**KIRKLEES METROPOLITAN COUNCIL
INVESTMENT & REGENERATION SERVICE**

Reference No:	2023/62/91595/W
Site Address:	690, Bradford Road, Fixby, Huddersfield, HD2 2JY
Description:	Erection of two storey side and single storey rear extensions with integral garage and external alterations
Recommending Officer:	Lucy Taylor

DECISION – REFUSED

Officer Report.

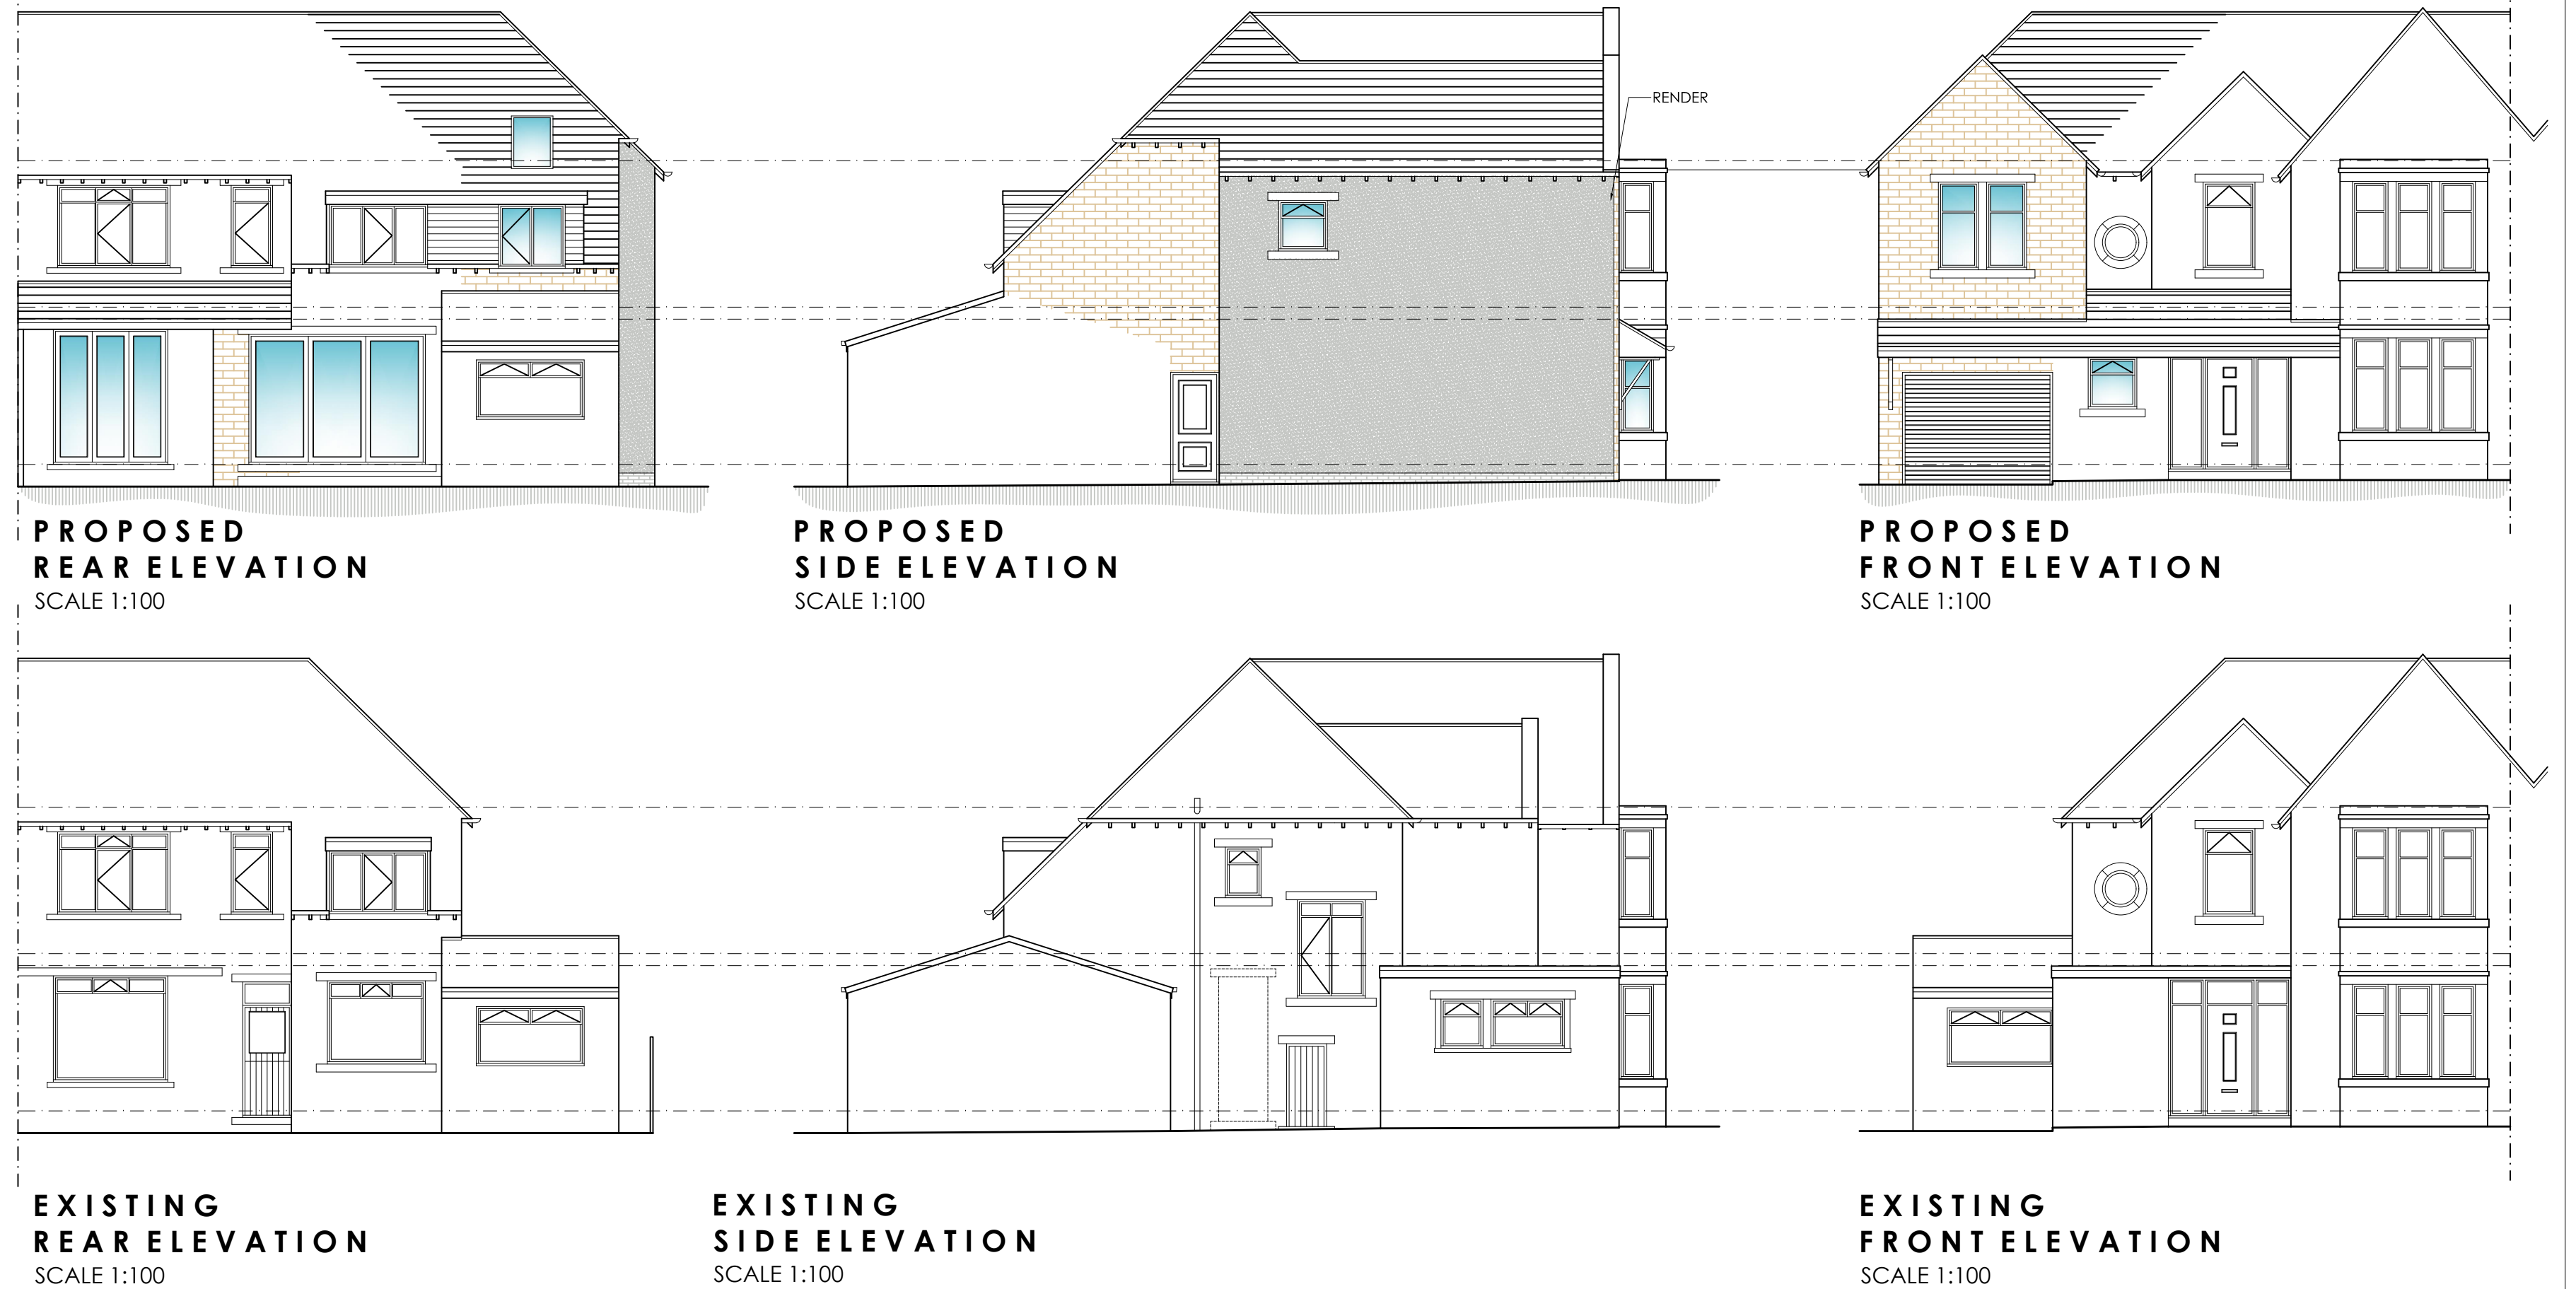
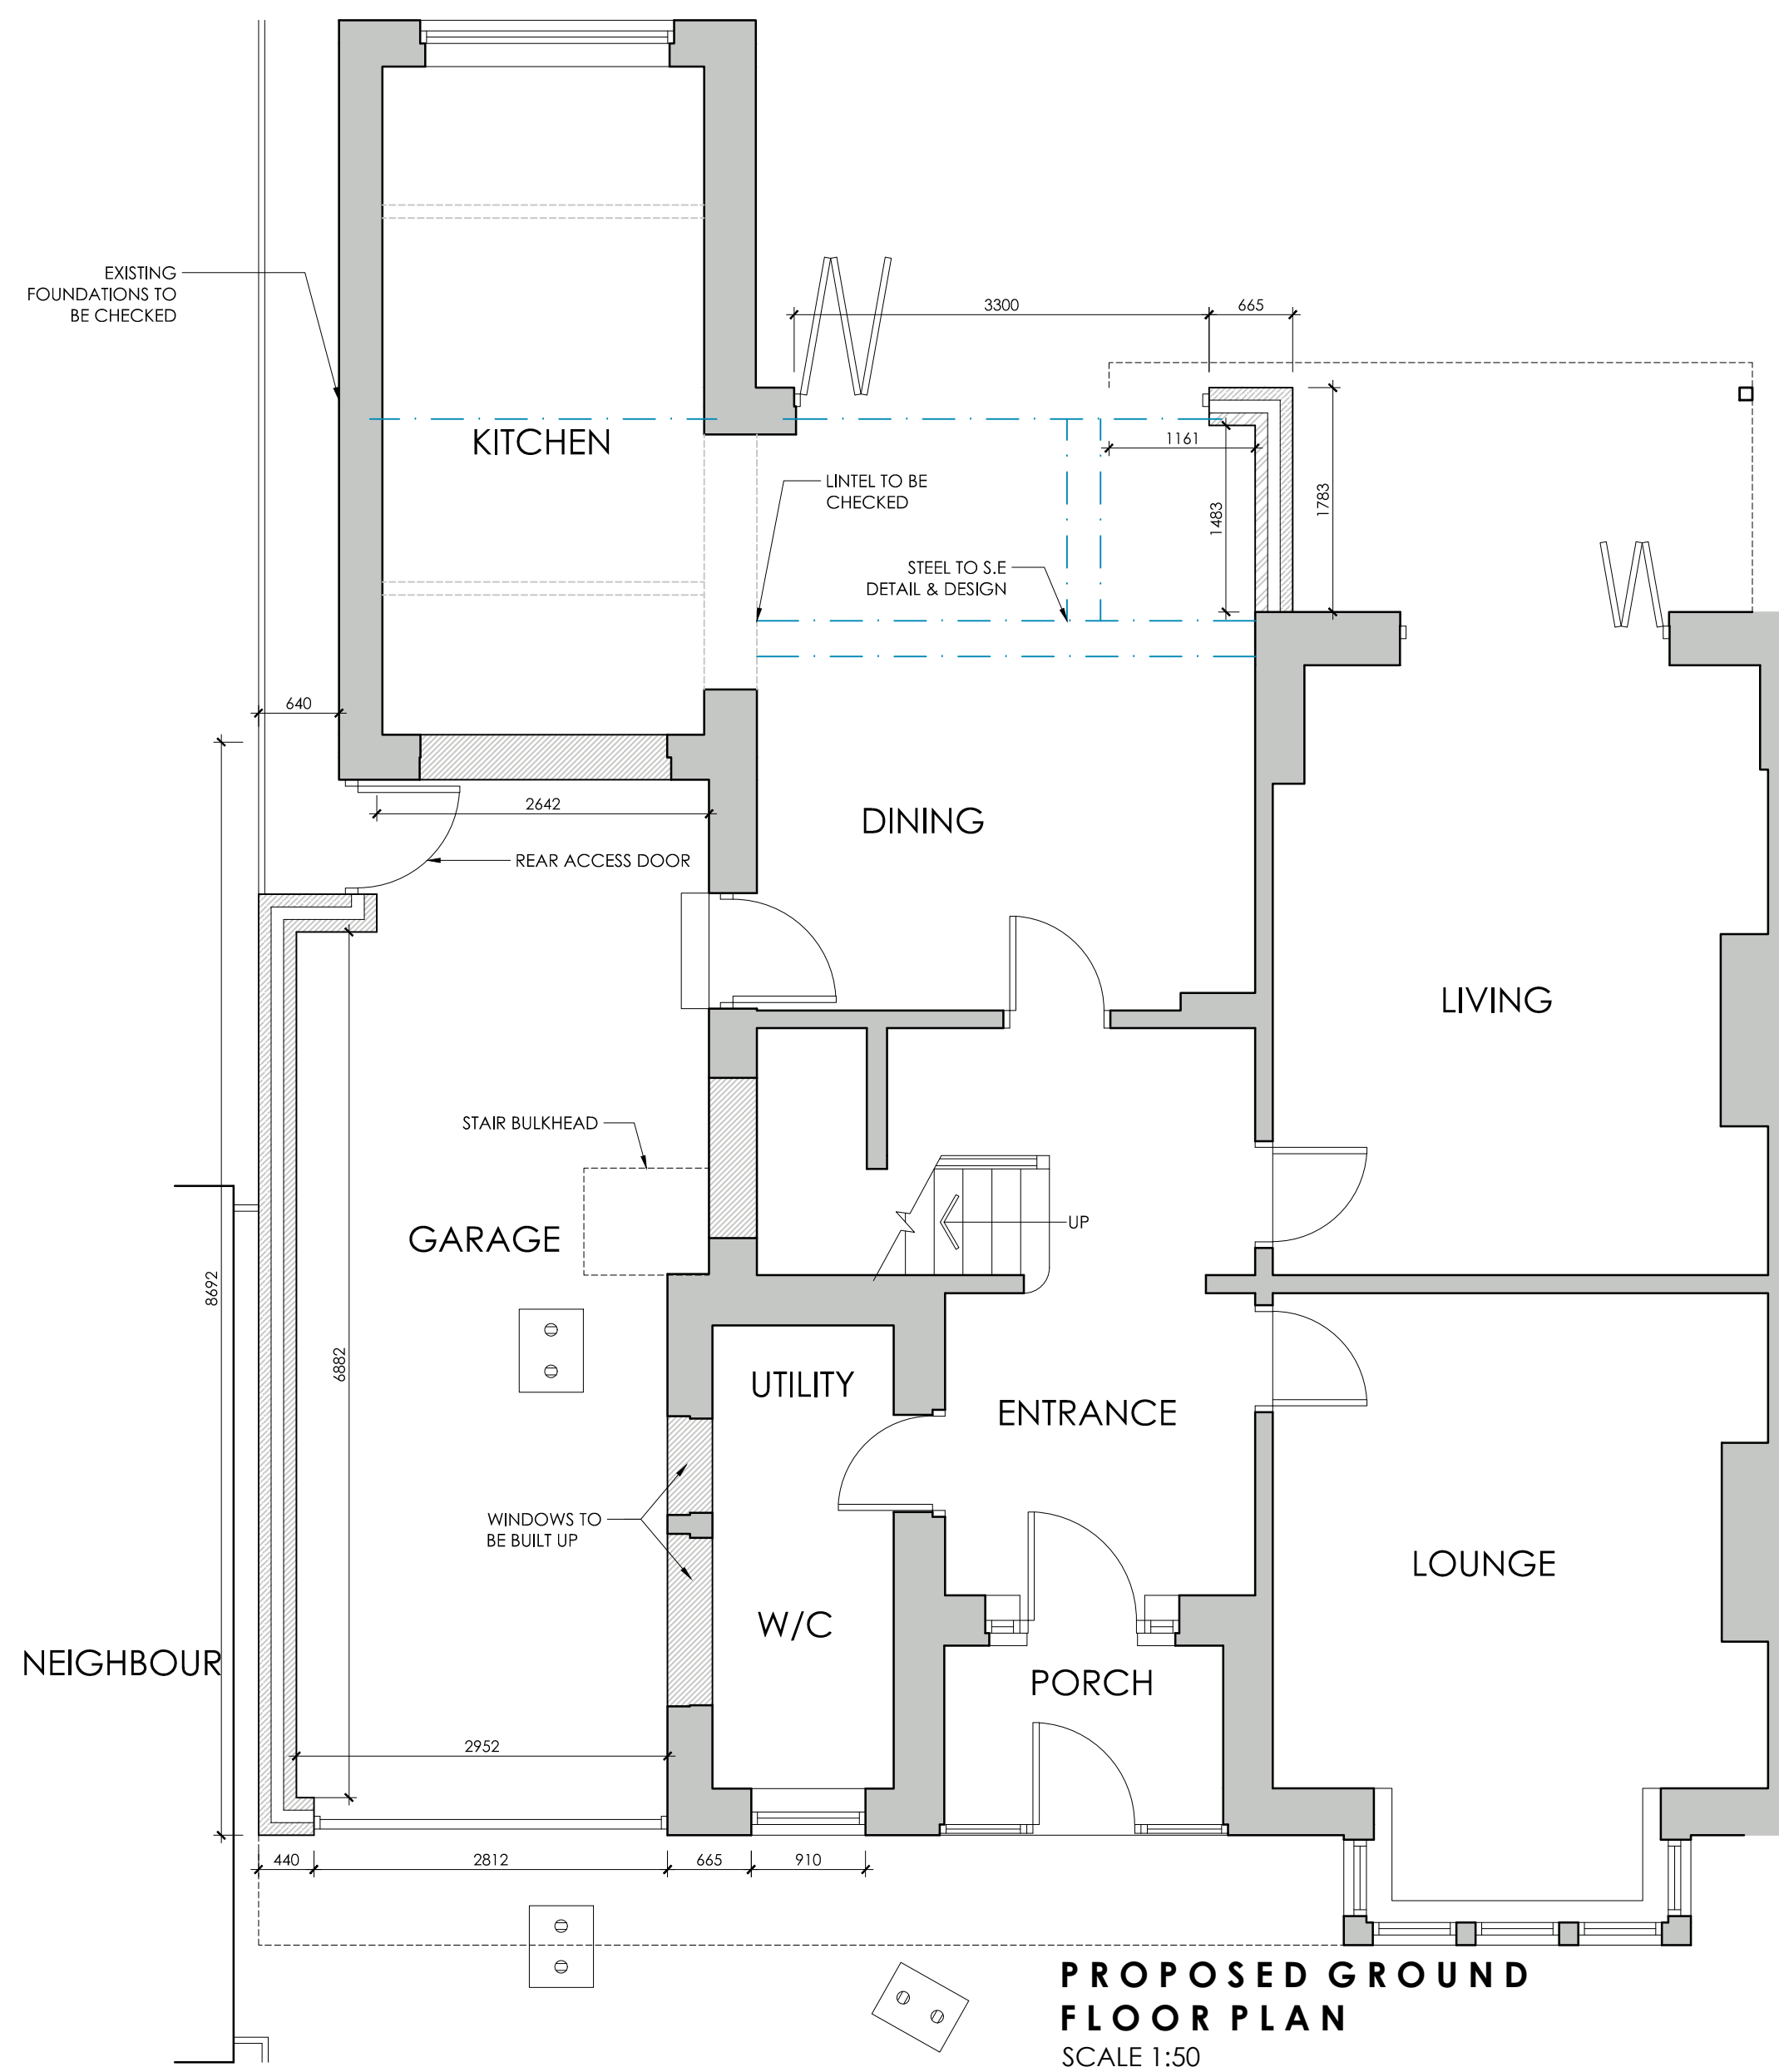
The proposed two-storey extension to 690 Bradford Road would not be considered to be subservient to the host property with regard to its size/scale, nor would its design or sitting be in keeping with the requirements of the House Extensions and Alterations SPD as set out above.

The proposed two-storey side extension would be considered to take up all of the space to the side of the host property. Whilst officer's note that the rearward section of the extension retains a small gap from the shared boundary, towards the front, the extension meets the side boundary of curtilage for a length of 5.5 metres. This would close the gap between the site and neighbouring property, causing a negative impact on the appearance and character of the street scene and posing detrimental potential for a terracing effect to be created along a non-terraced street.

It should be noted therefore, that the erection of the proposed two-storey extension would result in the loss of external access to and from the front and rear of 690 Bradford Road.

In addition, the proposed two-storey extension presents an undue extent of bulk and massing, failing to be set back from the principal elevation of the host property to any degree and failing to be set down from the roof pitch of the host property. In turn, the proposed two-storey side extension fails to be visually smaller in relation to the original house of 690 Bradford Road and would appear as unproportionate in scale.

The street is characterised by dwellings in spacious surroundings, it is considered the design of the proposal would impact upon the character of this part of the street as a result of its dominant design which would increase the massing / built form of the host property in a non-subservient manner which would not be harmonious to the character of the street.

For these reasons, it is concluded that the two-storey extension would be an unsympathetic addition to the host property of 690 Bradford Road. In addition, the proposed two-storey extension poses detriment to the established visual character of the wider locality. It is therefore concluded that the development scheme as applied for would not comply with policies within Chapter 12 of the NPPF, policies LP1, LP2 and LP24 of the Kirklees Local Plan or Key Design Principles 1 or 2 of the House Extensions and Alterations SPD.

1. The design, size and scale of the proposed two-storey side extension would not be subservient to the host property, and would result in an undue level of bulking and massing. The proposal is not considered to be harmonious with, and therefore causes detrimental harm to, the character of the host property and wider locality contrary to Policies LP24 of the Kirklees Local Plan, Key Design Principles 1 and 2 of the House Extensions and Alterations SPD and policies contained within Chapter 12 of the National Planning Policy Framework.
